From: sara@krdistrict.org
To: [Chace Pedersen](#)
Cc: ["kevin eslinger"](#)
Subject: RE: CU-24-00003 Schnebly Coulee Solar Farm - Re-Notice of Application
Date: Tuesday, August 20, 2024 12:49:31 PM

Thank you for the opportunity to comment on the Schnebly Coulee Solar Farm's updated application. The Kittitas Reclamation District (KRD) has concerns regarding the applicant's response to SEPA questions, specifically comment (c. Water Runoff (including stormwater), #1 (bottom of page 7)) *"Runoff onsite primarily occurs from the precipitation and snow melt. Natural drainage features found on-site typically run from the northeast to the southwest and connect with the unnamed Kittitas Reclamation District (KRD) irrigation canal located west and adjacent to the project. These drainage features with transport runoff into the KRD irrigation canal."*

Figure 4.4. Delineation of wetlands and other waters on October 18 – 21, 2022, within the Schnebly Coulee Solar Energy Project Area, Kittitas County, Washington (ESA 2024).

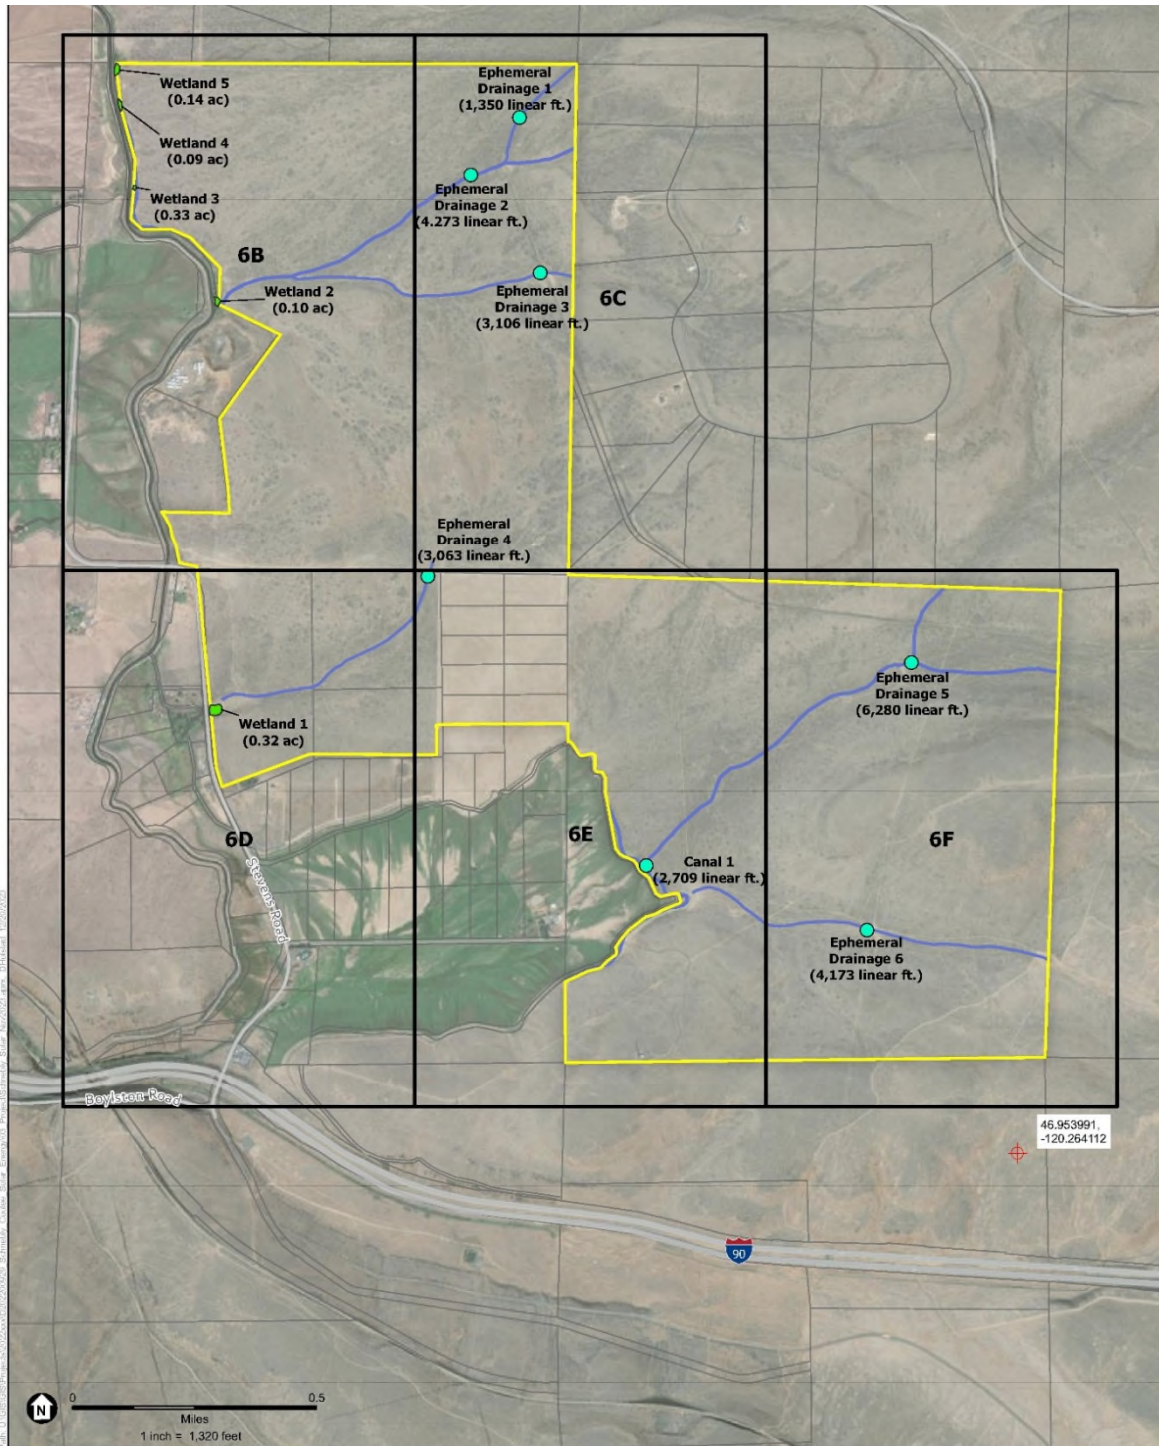
The natural runoff flows from Schnebly Coulee currently present no issues within the existing natural drainage systems. Water runoff is directed under the North Branch canal, not into the canal itself. Any modification to the natural drainage system could alter the ability of the existing North Branch canal infrastructure, an undershot beneath the canal, to handle an increase in runoff. It is unacceptable to direct runoff directly into the canal for several reasons.

potential issues caused by the project. The KRD needs to reiterate that it will not allow any water runoff from the project site to enter the canal system. Additionally, the North Branch is owned in fee by US Bureau of Reclamation and as a result a modification to the undershot necessary to handle increased flows will require a license from USBR.
